Your Ref :
Our Ref : FP/57/18/NMA

Non-material amendment following the grant of FP/206/17/HH to re-introduce a proportion of original glazing arrangement, remove central vertical pillar between the two garage doors & introduce a slot window into the former lift shaft.

Beach Lodge, 1 Strand Way, Felpham,

Please note that Drawing PL.104.C "Proposed Elevations" now forms part of the approved planning drawing (replacing PL.104.A).

Proposed Elevations

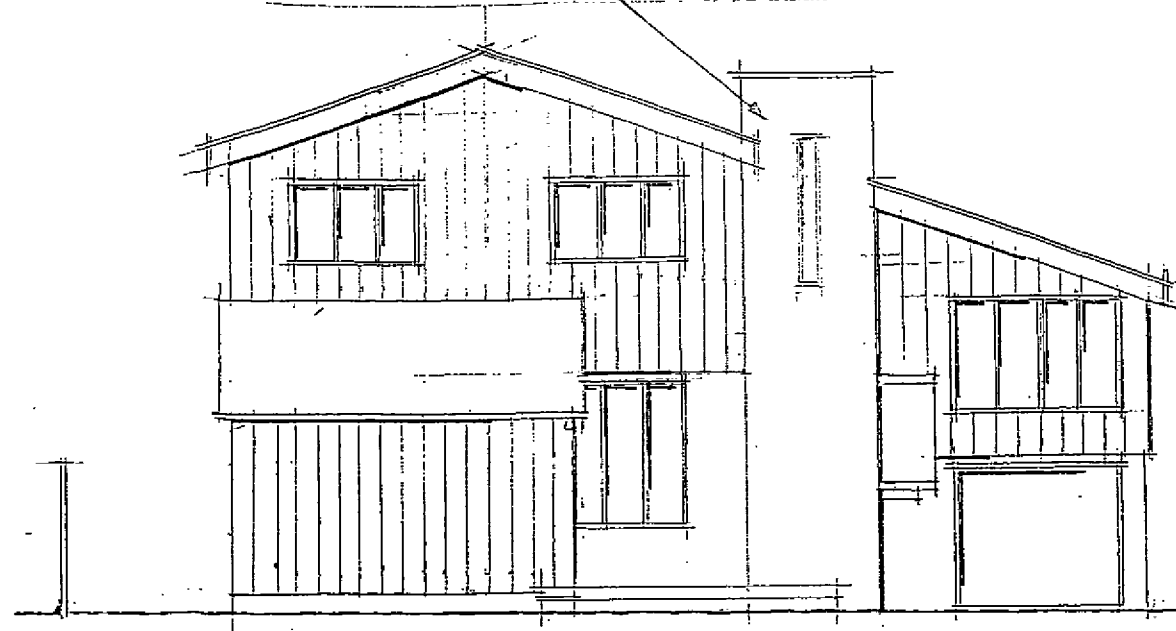
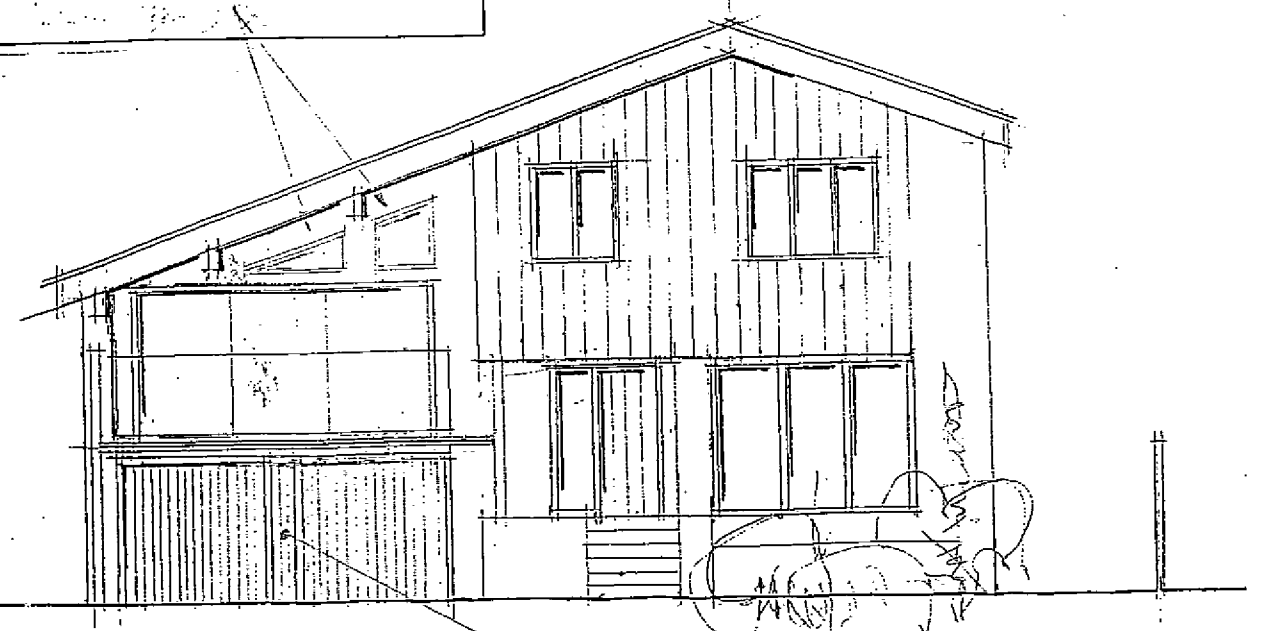
- (1) Re-introduce a proportion of original glazing to an upper area of a vaulted ceiling in the front elevation;
- (2) Remove the central vertical pillar between the two garage doors to facilitate a wider garage; and
- (3) Introduce a new slot window into the former lift shaft to serve the first floor storage area.

The reasons that these proposals have been accepted as Non-Material Amendments is because the changes do not materially alter the planning permission and do not necessitate additional consultation with local residents. It is noted that the new rear slot window will face a neighbouring property but this is considered acceptable having regard to the narrow width of the window and the distance between the window and the closest property to the north. The changes can therefore be considered as an NMA under section 96A of the Town and Country Planning Act 1990.
